Department for
Business, Energy
& Industrial Strategy

Our Ref: EN020022

Application for Development Consent (“the Application”) by AQUIND Limited (“the Applicant”) for an Order granting Development Consent for the proposed AQUIND Interconnector (“the AQUIND Interconnector project”)

REQUEST FOR INFORMATION

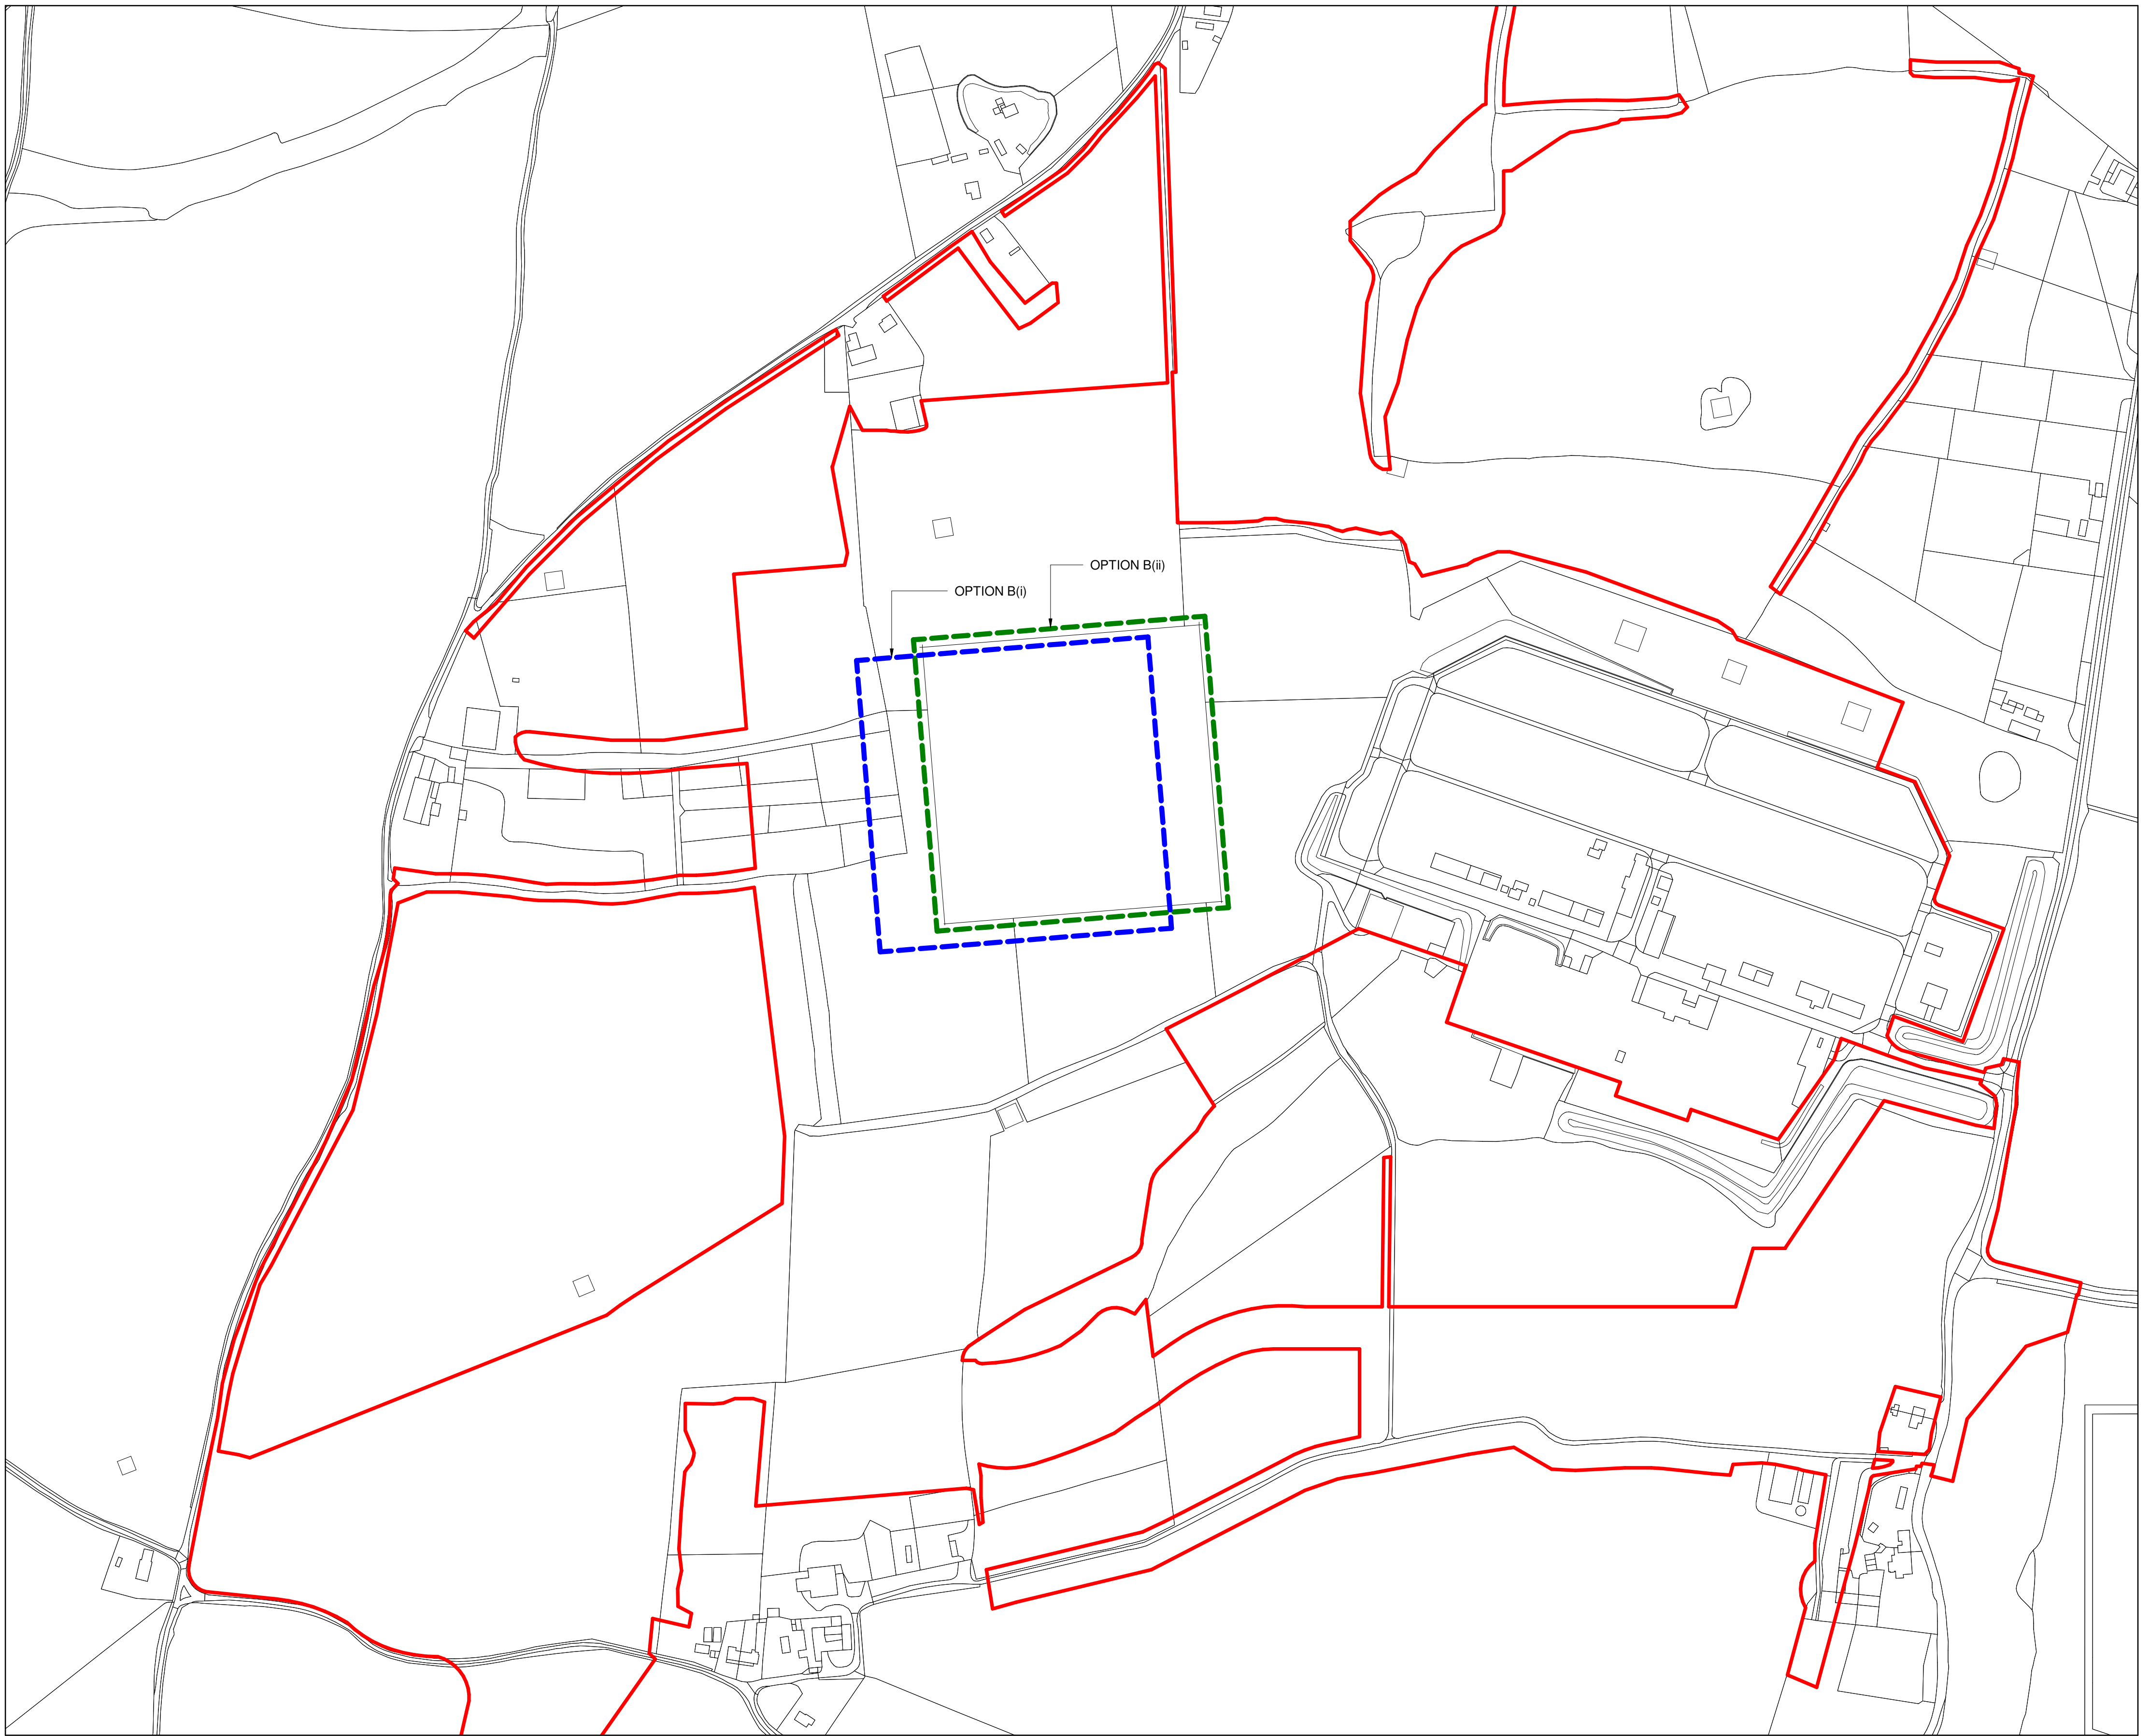
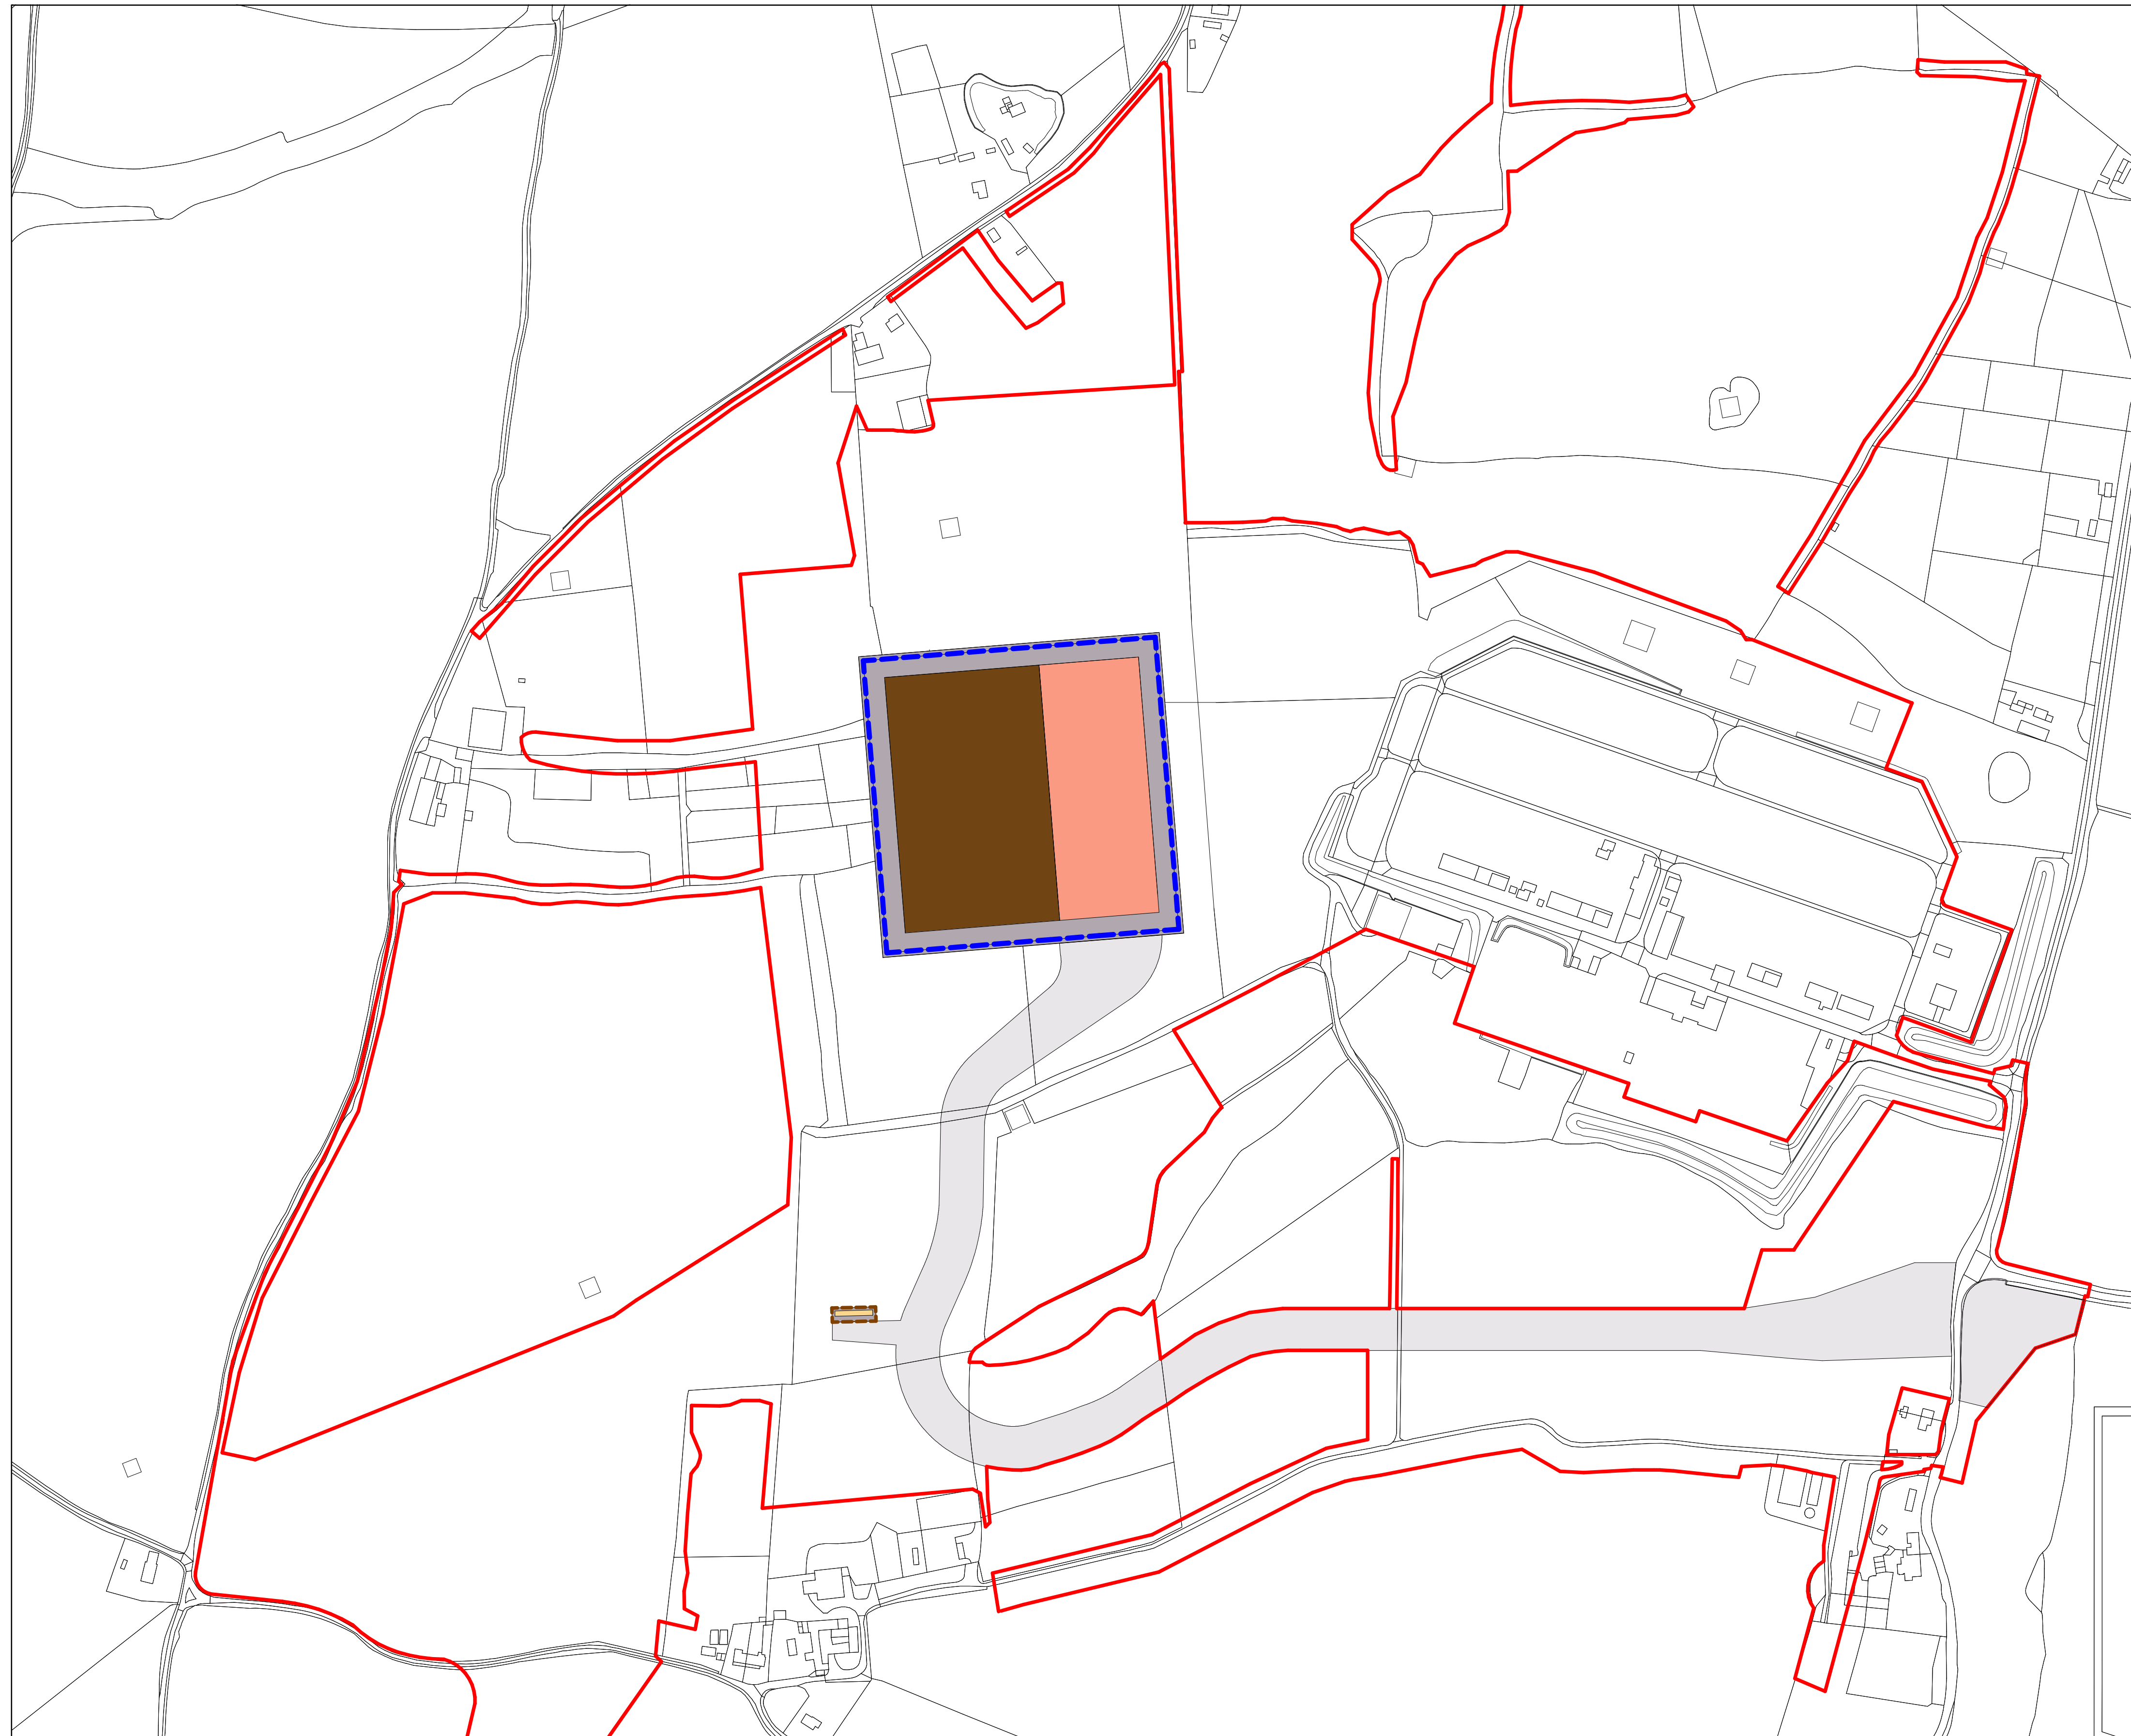
- Justification for the extent of compulsory acquisition powers sought at the plots of land associated with the commercial telecommunications buildings on the site of the converter station. The Secretary of State notes that the Applicant has advised that these buildings would not be required should the equipment required for commercial telecommunications be removed. The Applicant should confirm the reasons as to why the full extent of land will still be required if those telecommunications buildings are removed from the development consent order.
